**REGIMENT STUDENT ACCOMMODATION
& MIXED USE REDEVELOPMENT – SSD-7417**

City of Sydney Council – Consultation Meeting

MEETING MINUTES

16th January 2017 3pm

Section B
1 : 200

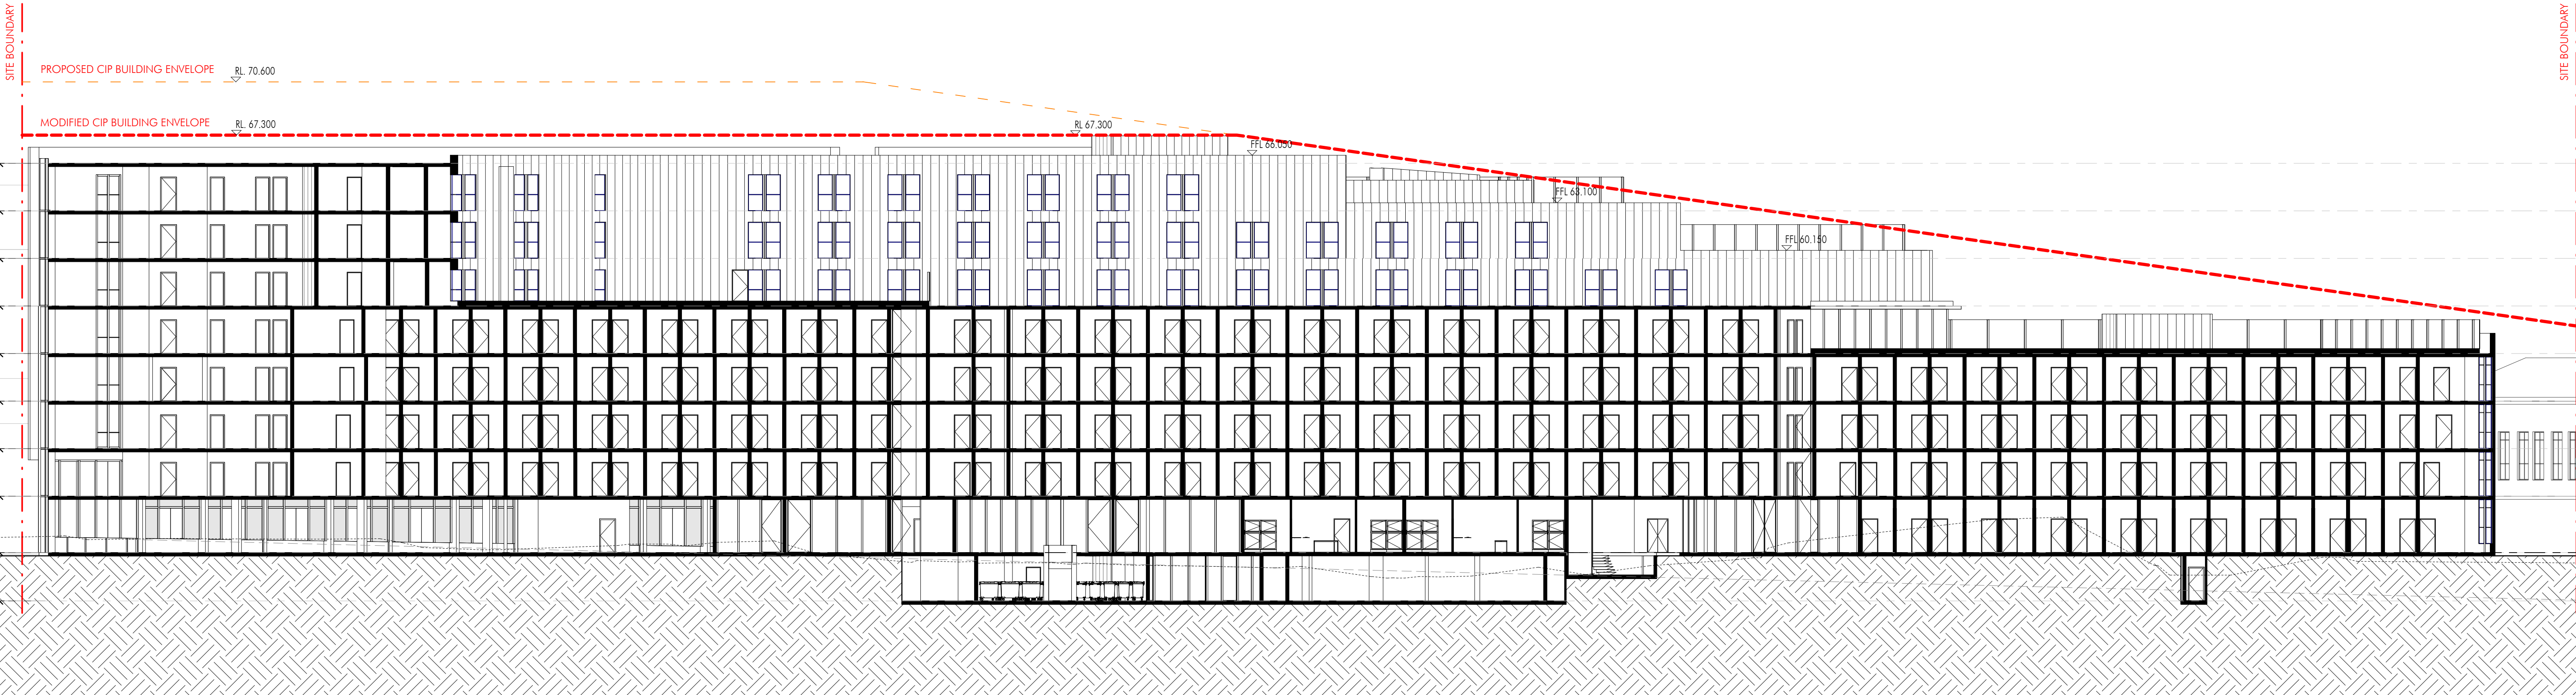
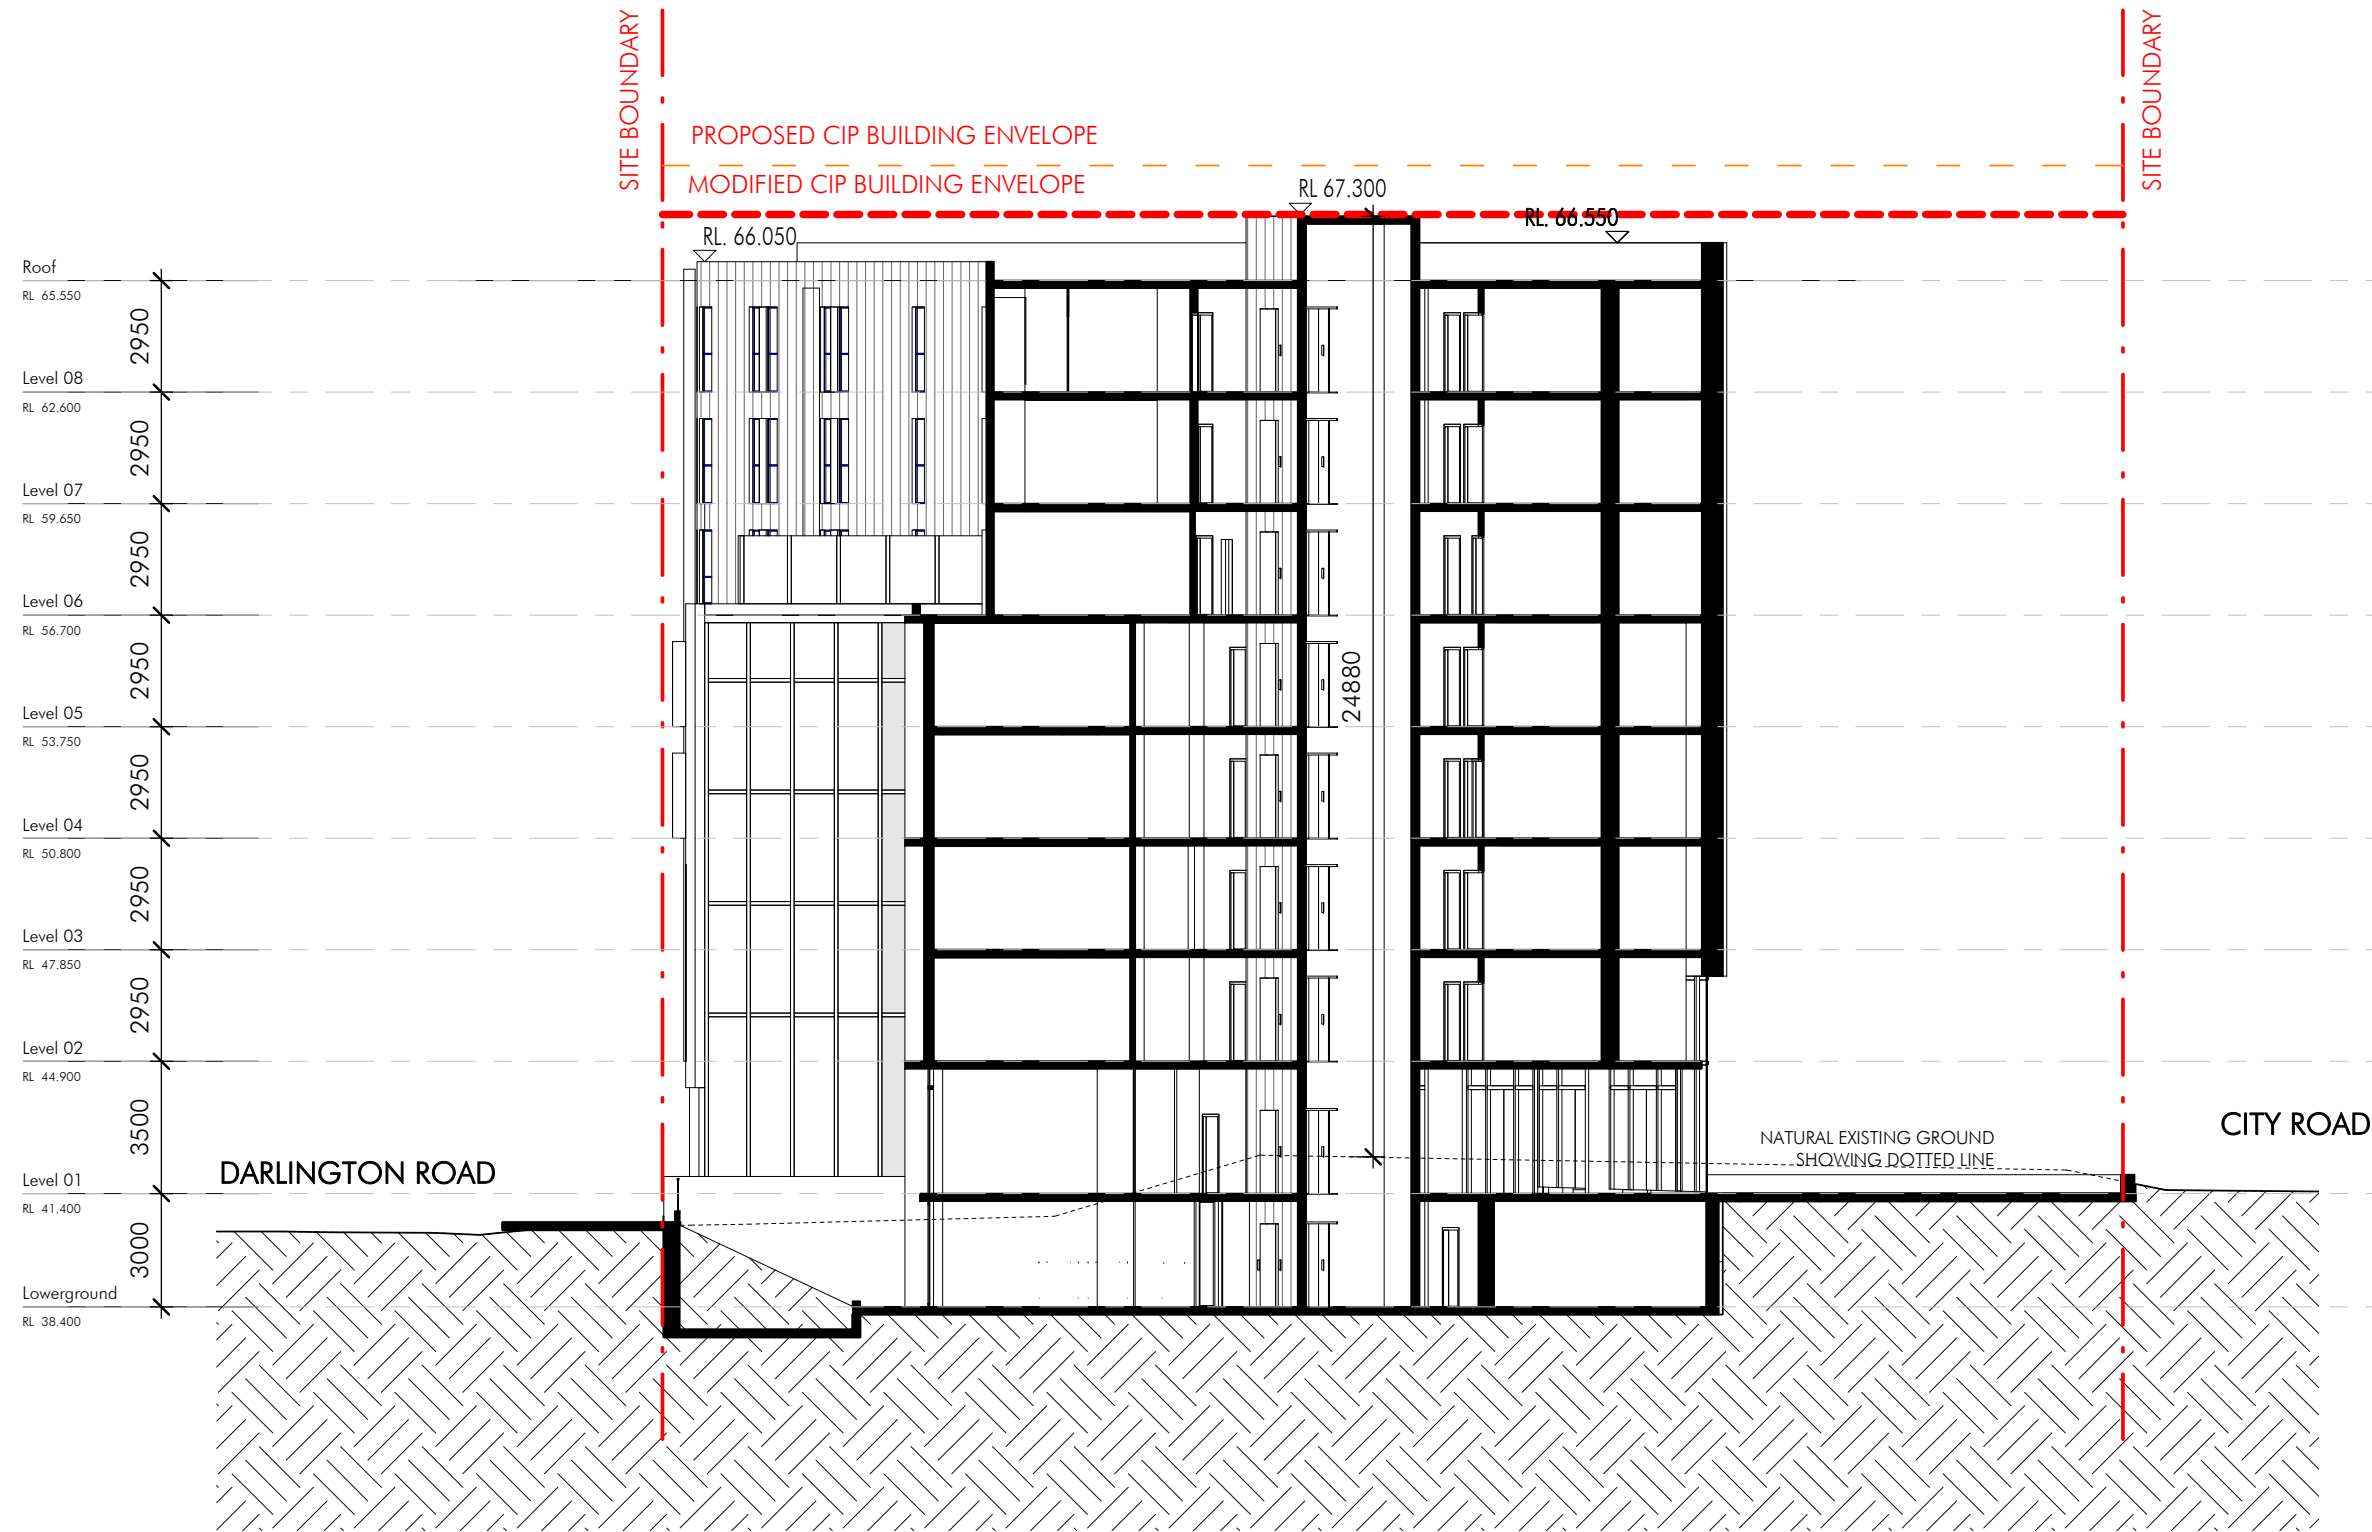
- CoS requested for the UoS to include a cross-section from Darlington Road to City Road via the recessed landscape buffer fronting Darlington as part of the SSD submission.

Typical Standard Room Layout and Amenities.

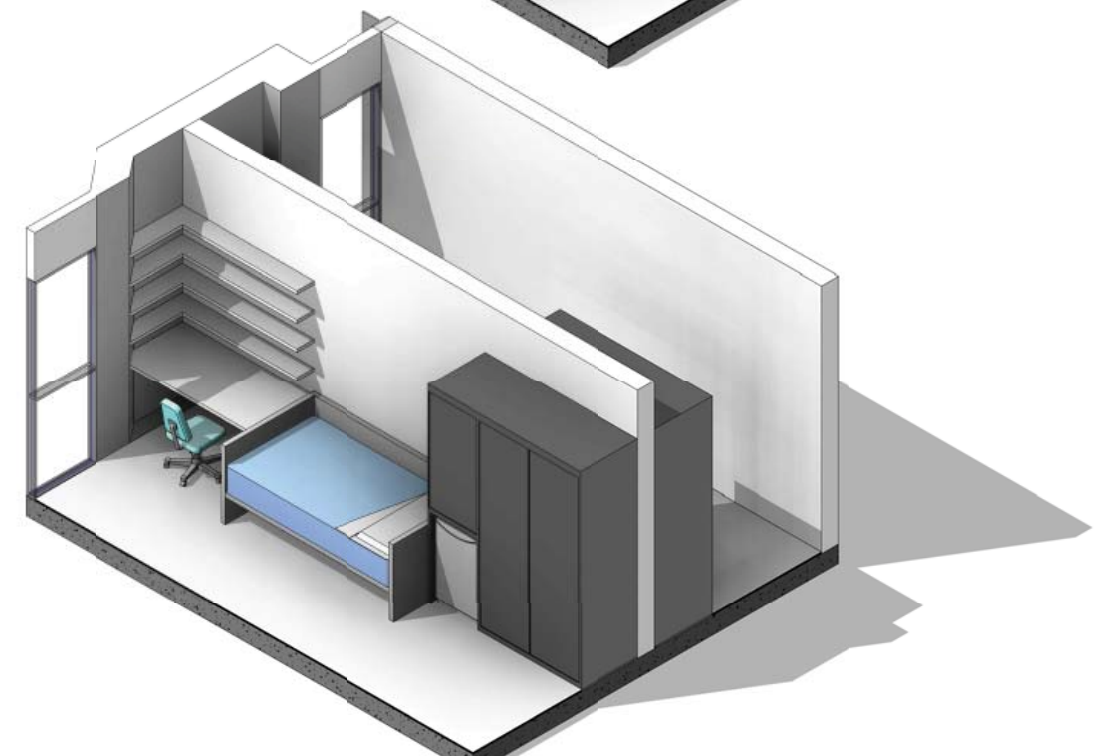
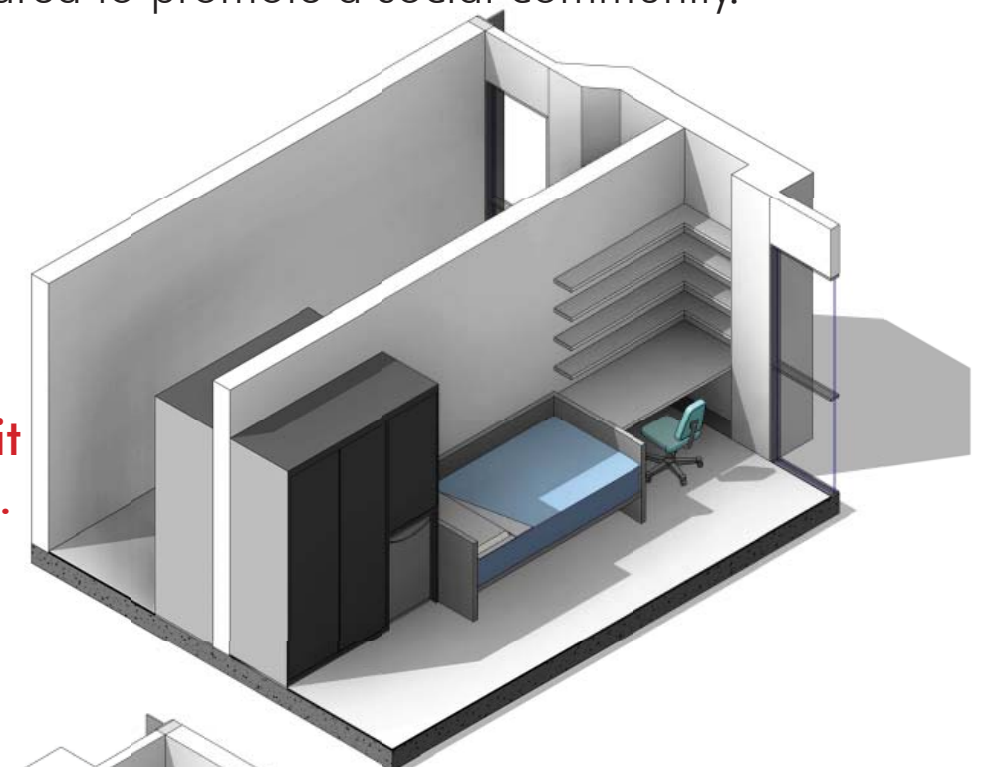
- CoS (CC) advised the Affordable Housing SEPP requires 12m² minimum per bedroom.
- UoS responded with a summary on other shared and common areas supplementing the bedrooms and the juxtaposition to surrounding Darlington campus facilities.
- The example of the Queen Mary Building was used as justification for the smaller rooms as it has smaller bedrooms and was approved by City of Sydney Council.
- UoS is to forward to CoS (CC) a draft of the SSD justification for smaller bedroom sizes for early Council feedback, prior to SSD lodgement.
- The City of Sydney at this stage does not accept the reduced size bedrooms. Justification is required as to why the designs do not meet the minimum 12m² in the SEPP.
